From: Laura Gibbons <Laura.Gibbons@arun.gov.uk>
Sent: 19 October 2021 14:23
To: Planning.Responses <Planning.Responses@arun.gov.uk>
Cc: Michael Eastham <Michael.Eastham@arun.gov.uk>
Subject: RE: Planning Consultation on: A/188/21/DOC

Application No: A/188/21/DOC

Site Address: Land at Dappers Lane Angmering Littlehampton

Description of Works: Approval of details reserved by condition imposed under ref A/76/20/PL relating to Condition Nos 17 - existing & proposed ground levels, 18 - surface water drainage, 19 - maintenance & management of surface water drainage, 21 - discharge flows to watercourses and 22 - foul drainage system

Basin Floatation Calculations

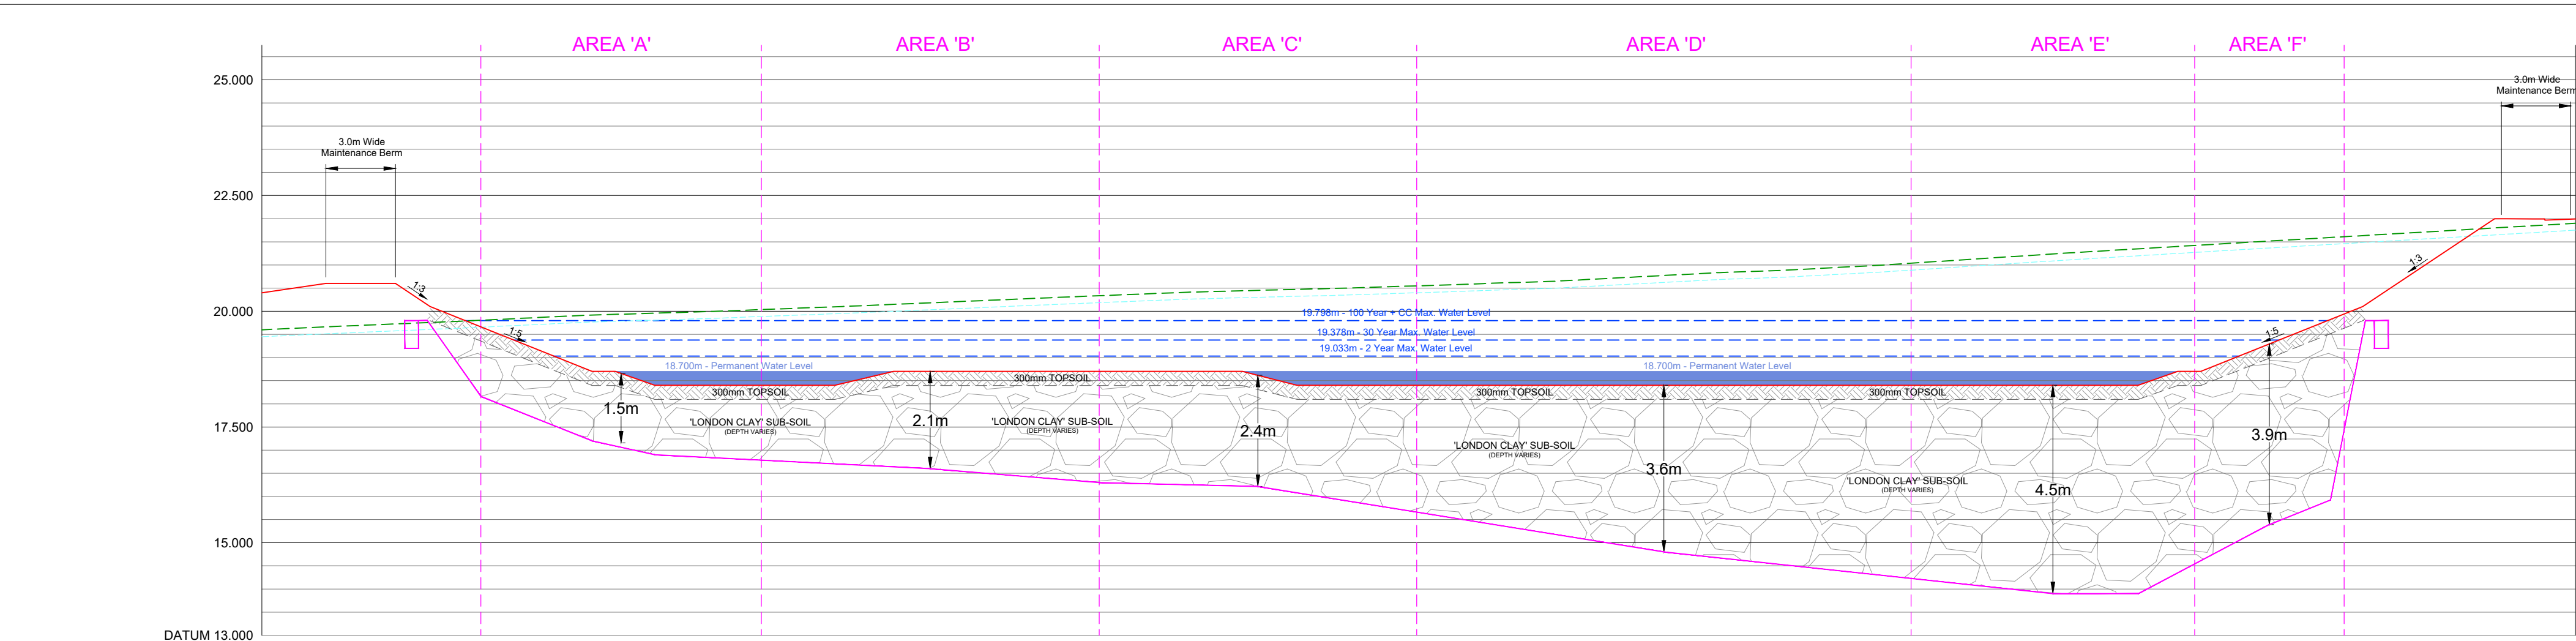
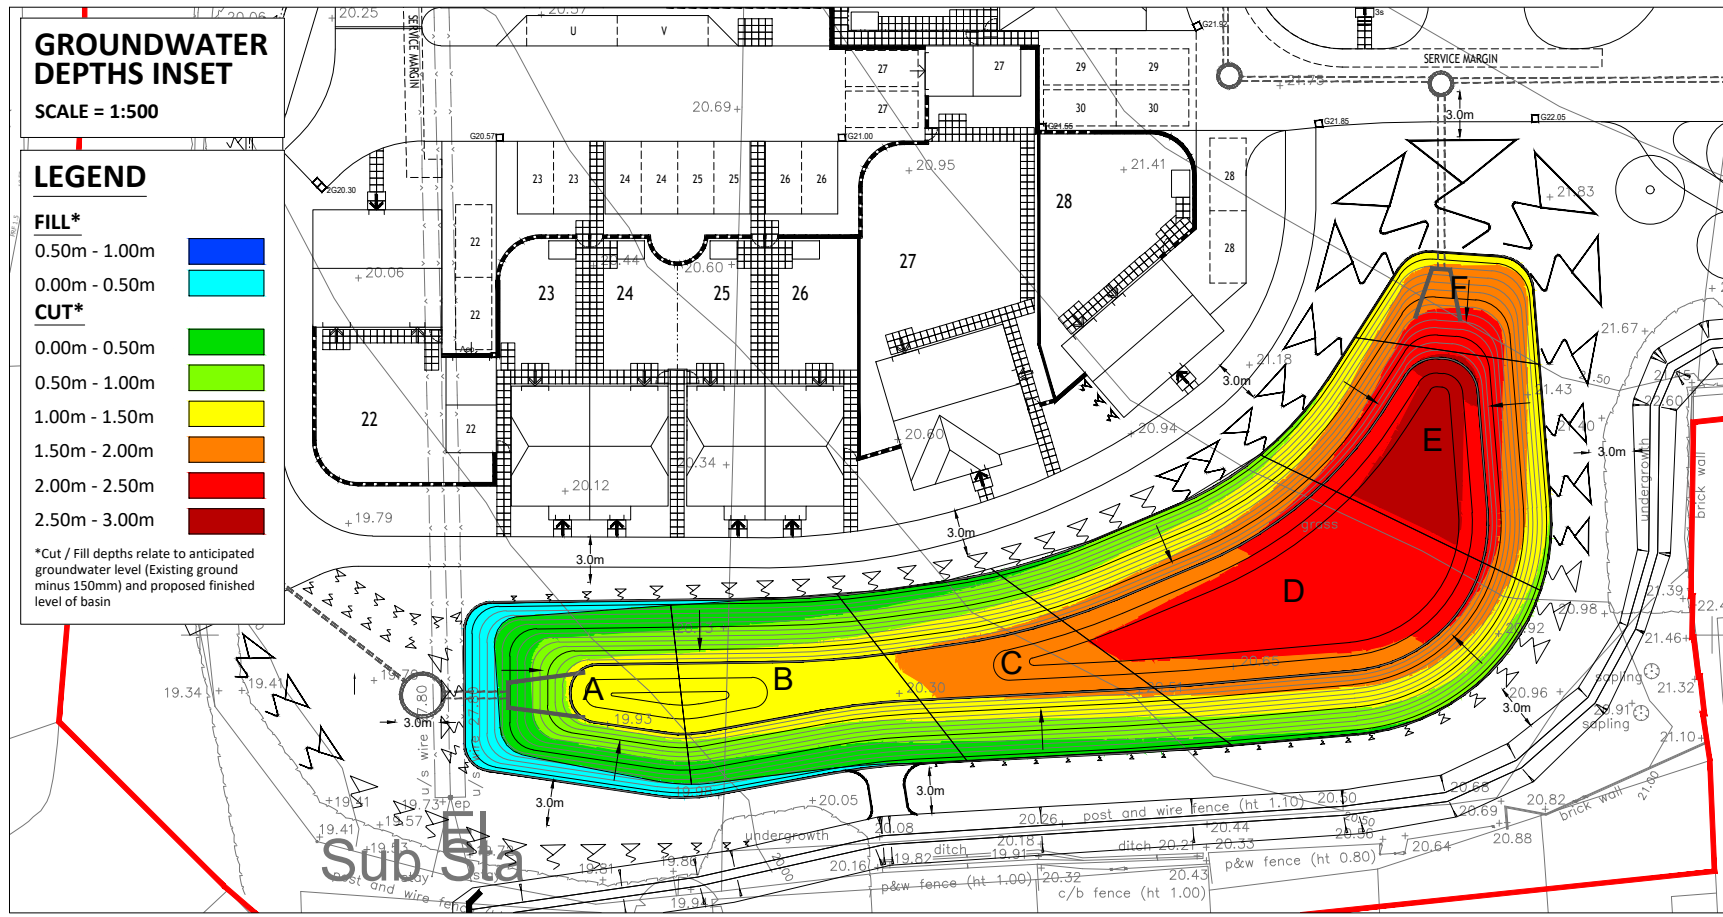
No flotation calculations have been provided, a further statement from a geotechnical company has been provided, this does not alter our previous requests for features to be lined and for flotation calculations to be provided. The majority of Angmering sites in this area have groundwater at around 1m depth or shallower, design must demonstrate that groundwater will be kept out of attenuation features now and for the lifetime of development. **BGC 30/08/21 - Attenuation Basin flotation calculations illustrated on drawing; 20079/211. Cellular Storage flotation calculations illustrated on word document; 20079 – Cellular Storage Flotation Calculations – 2021.08.04.**

Calculations should apply a factor of 0.9 to resisting forces, and a factor of 1.1 to destabilising forces. Furthermore the concrete cover slab to crates will also displace groundwater, this has not been accounted for in calculations and design. – Flotation calculations updated to reflect 0.9 factor to resisting forces and a factor of 1.1 to destabilising forces. Upon revising our calculations we can confirm that no concrete slab is required, please refer to flotation

calculation word doc PDF's and drawing numbers 20079/315 C, 20079/316 C & 20079/211 D. Okay, point closed.

Drawing: 20079 - 211 C

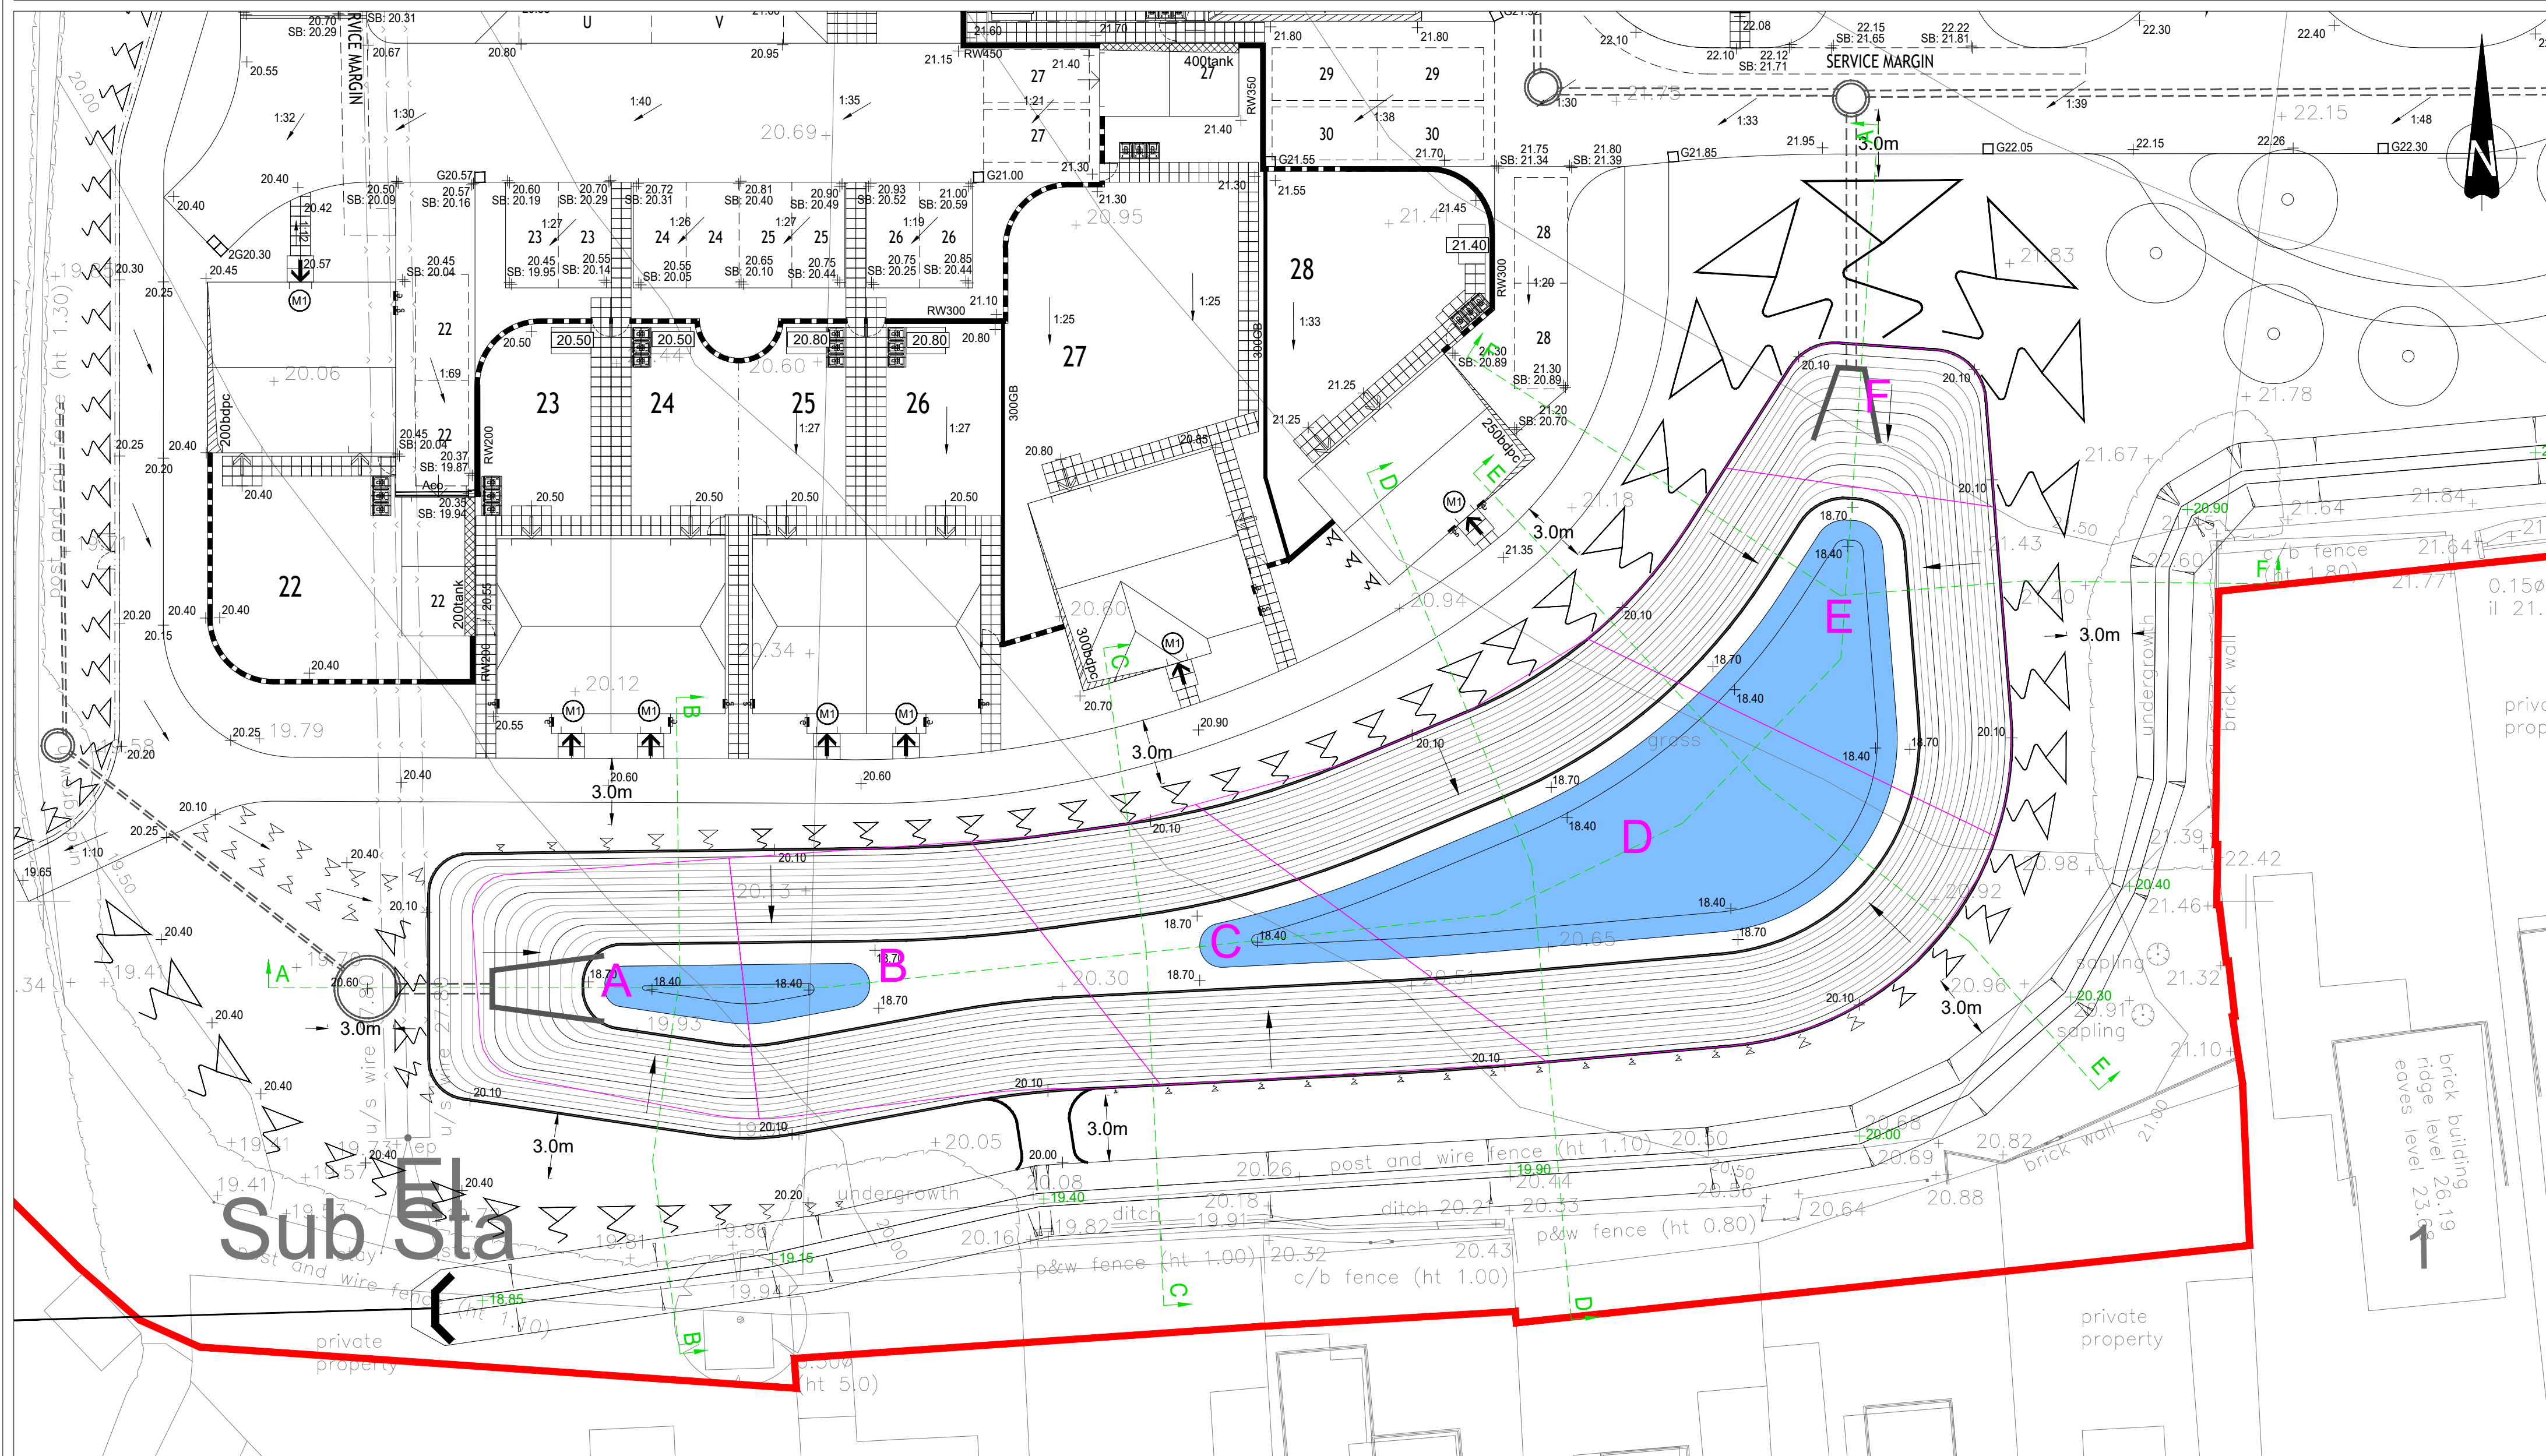
It is unclear how it will be possible to excavate 4.5m below the base of the attenuation basin and line it with an impermeable liner. Groundwater will make construction exceptionally difficult, if not impossible. The proximity of the basin to the adjacent watercourse will also prevent adequate batter, and will necessitate significant temporary works to stabilise excavations. Cost of replacement of liner at end of design life is an unfair burden upon residents. Also unclear how it will be possible to construct the basin with such varying liner depth accurately. – Persimmon have not expressed any concerns over the ability to construct our latest design, therefore we foresee no issues. Please see comments of 12/10/21, awaiting full response. Excavating over 6m only 3m away from the watercourse, and the acceptability of proposals throughout the lifetime of development, are seriously questioned.

REF 20079 - CC28

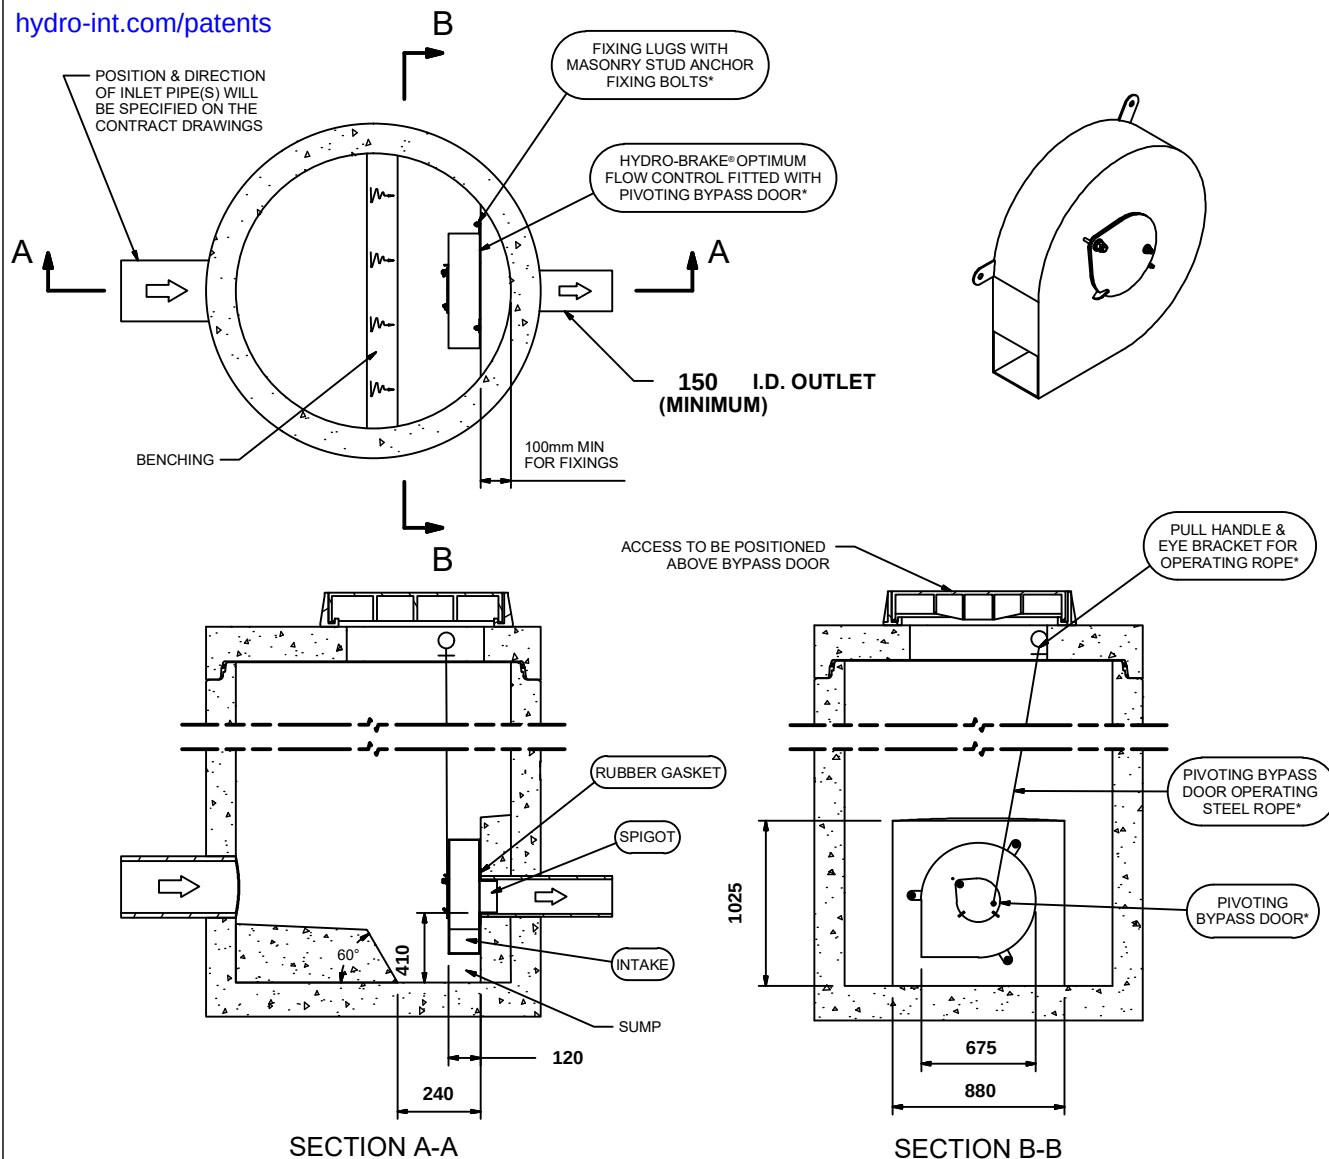
Overflow levels at CC12 and CC28 appear to be below 100 year plus 40% cc water level. — Checked, and can confirm the overflow levels are above the 100 year + 40% CC water level within the relevant Node/MH. Okay, point closed.

Drawing Status	CONSTRUCTION
Scale	A1
Date	October 2020
File	20079/dwgs/civils/current
Drawn	LJ
Checked	
Drawing	
20079 - 326 E

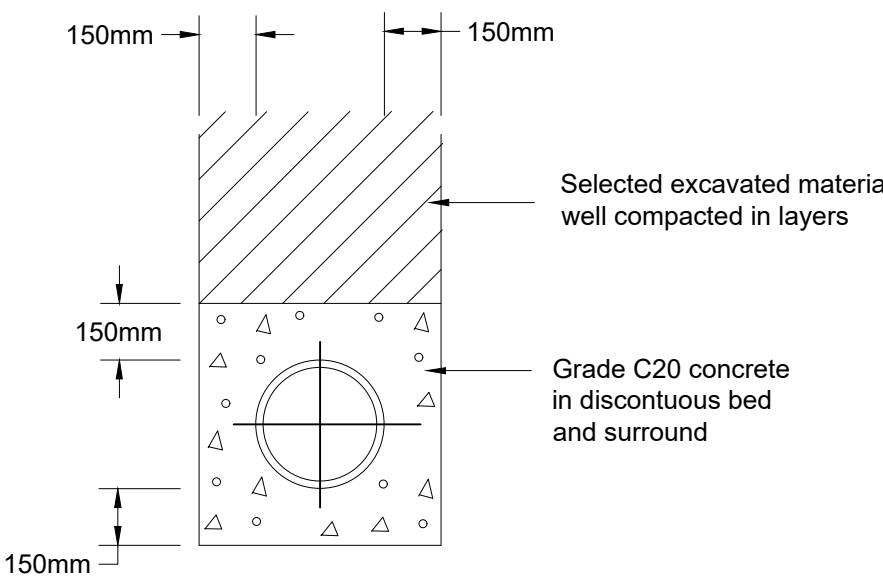
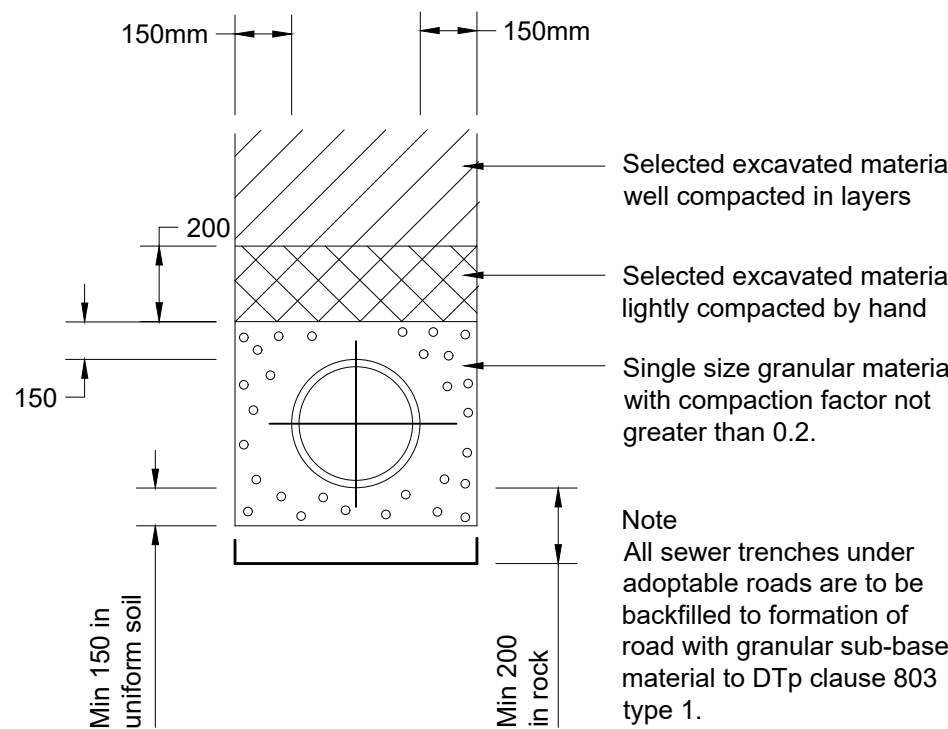
Please detail what bed and surround requirements are for pipes outside of adoptable highways. – Bed and surround detail added to private drainage details. Apologies, this only appears to show class S bedding, are you confident that cover depths everywhere within private extents are sufficient to not require concrete bed and surround?
